CITY OF ALBUQUERQUE

December 5, 2018

RE: **13424 Cedarbrook Ave NE**
Request for Pad Certification – Not Accepted
Grading Plan Stamp Date: 11/27/18
Certification Dated: 12/3/18
Drainage File: F23D013

ENGINEER'S SEAL 11/27/18 DAVID SOULE P.E. #14522	13424 CEDARBROOK AVE.	DRAWN BY DEM
	GRADING AND DRAINAGE PLAN	DATE 9-23-2018
	 Rio Grande Engineering 1800 CENTRAL AVENUE SUITE 301 ALBUQUERQUE, NM 87108 (505) 872-0000	SHEET # 1 OF 1
		JOB # XXXXX

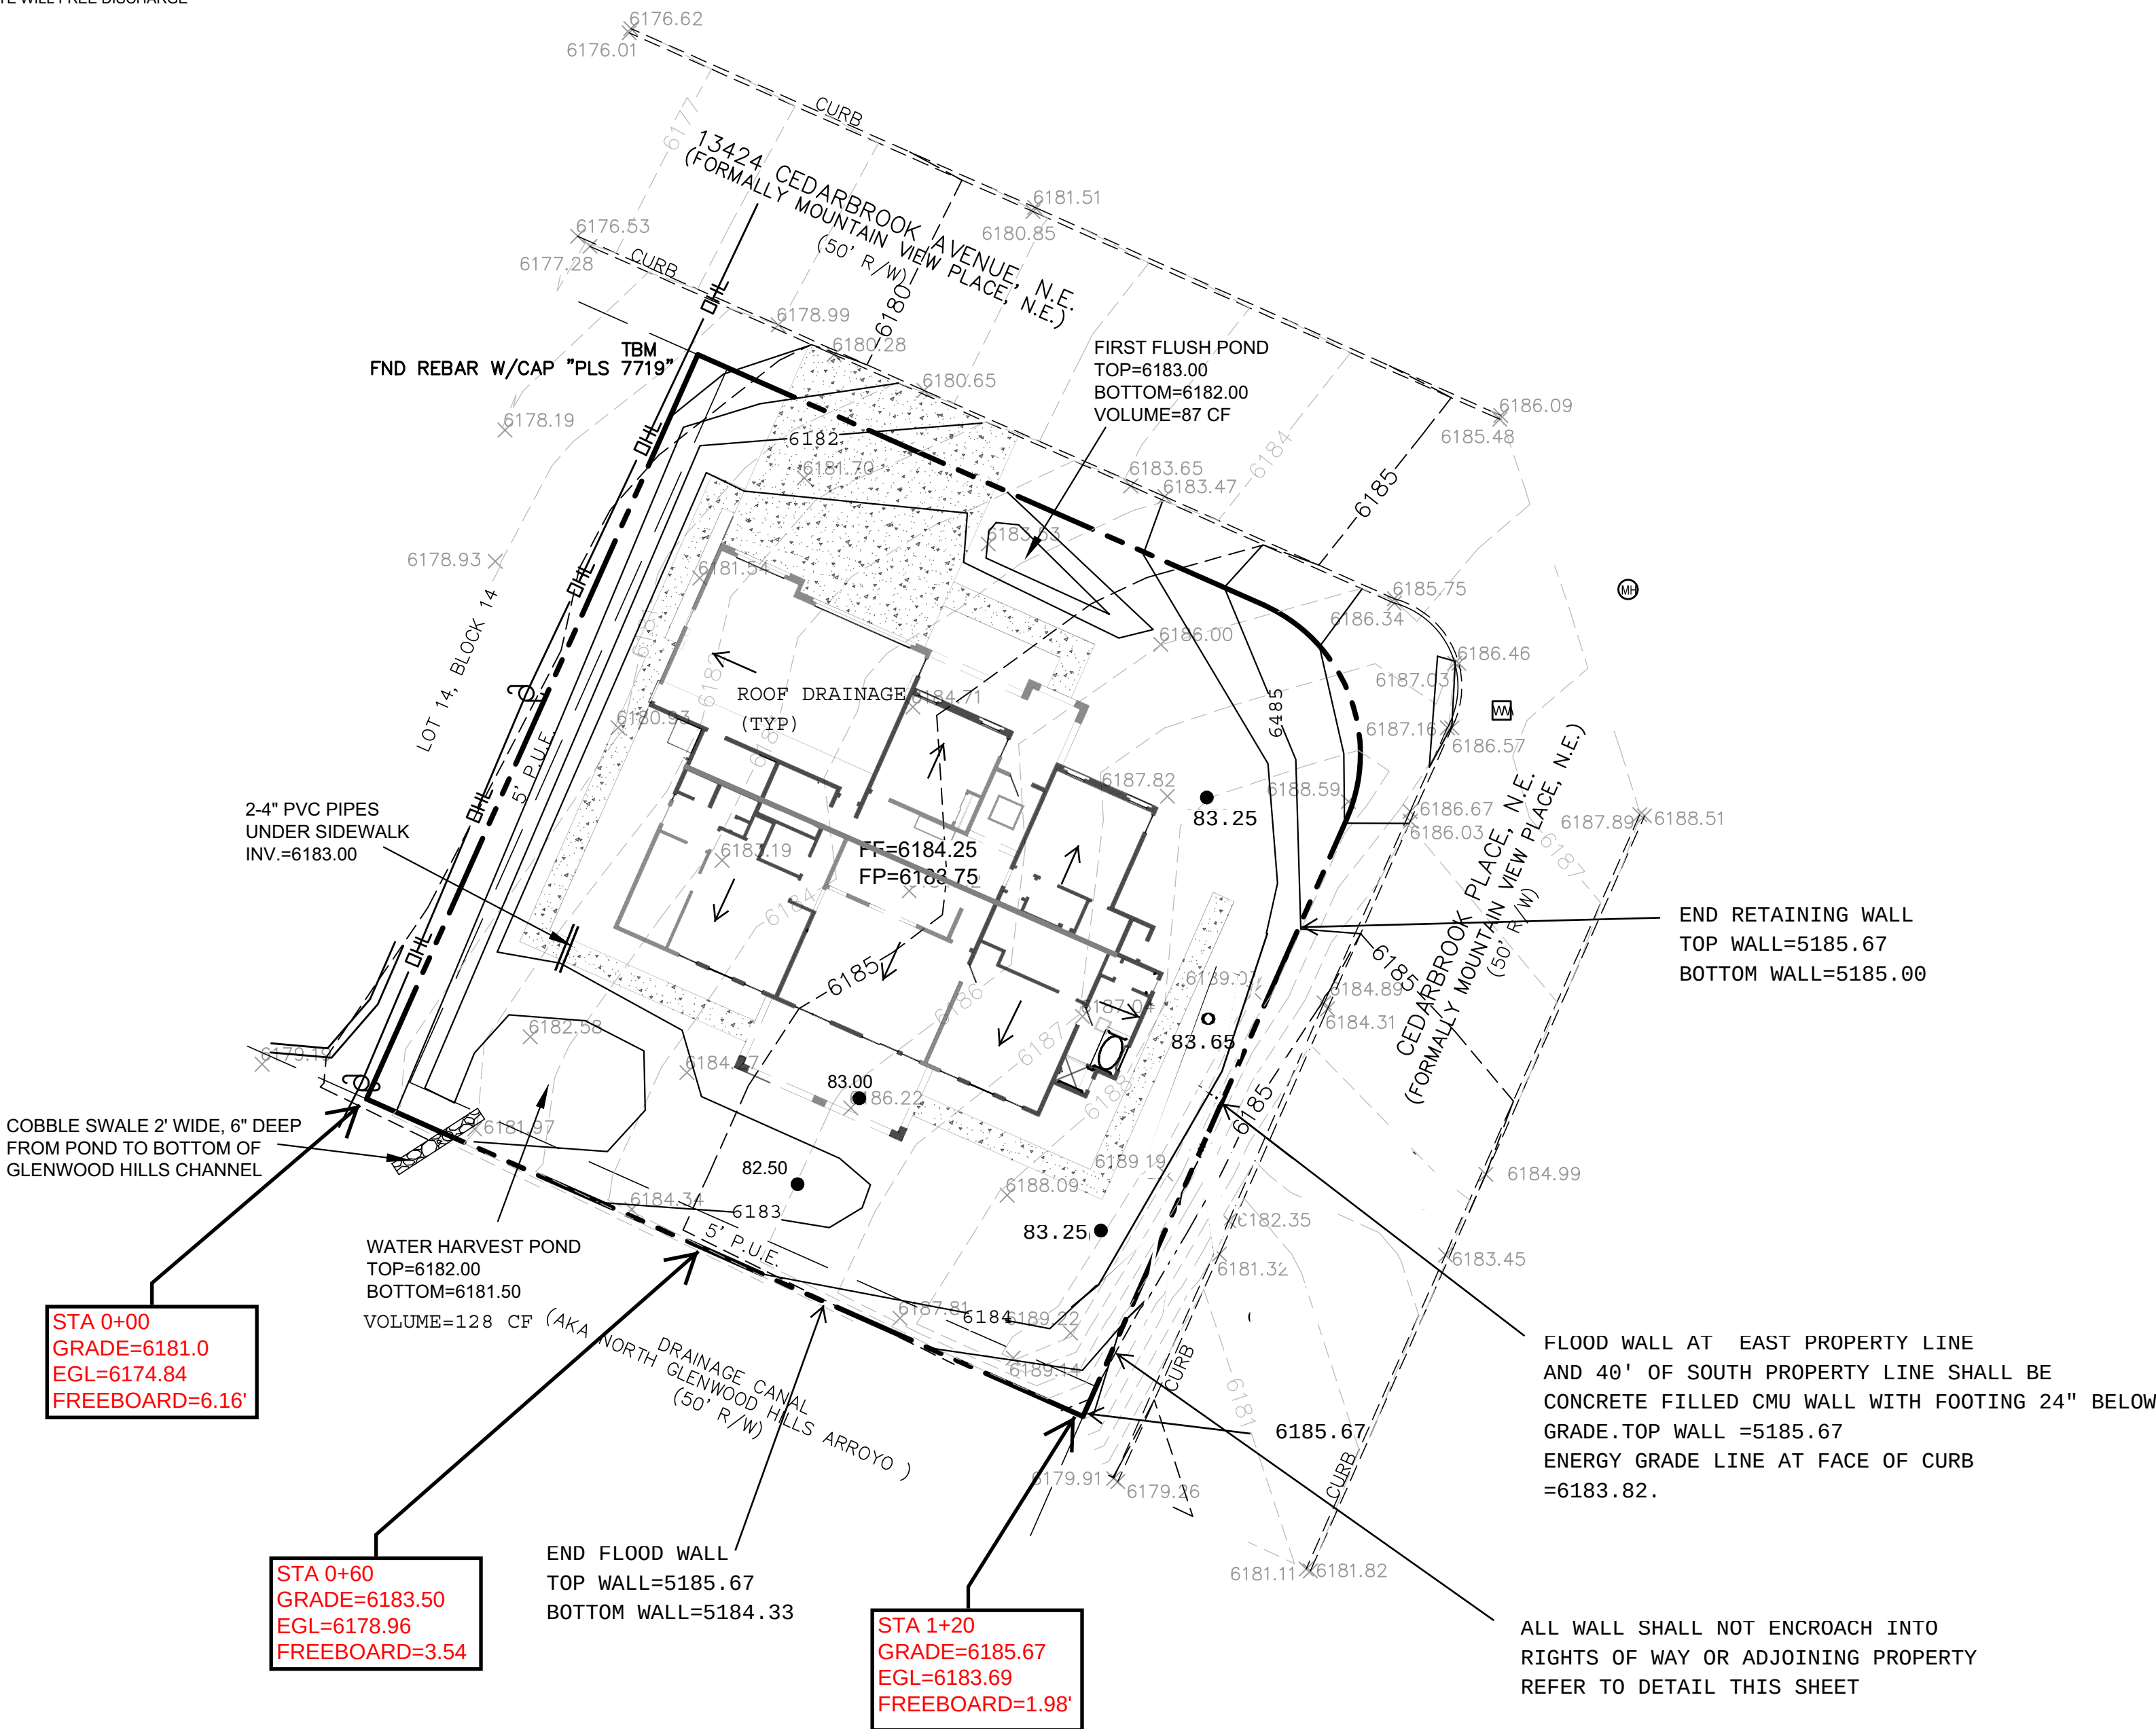
1. Survey the building pad, east and south property lines and provide the surveyed elevations on the Grading Plan.
2. Complete the grading along the east property line and the southeast corner and prepare the subgrade for freeboard wall construction; do not leave the cut-bank at property line, do not grade into the arroyo ROW.
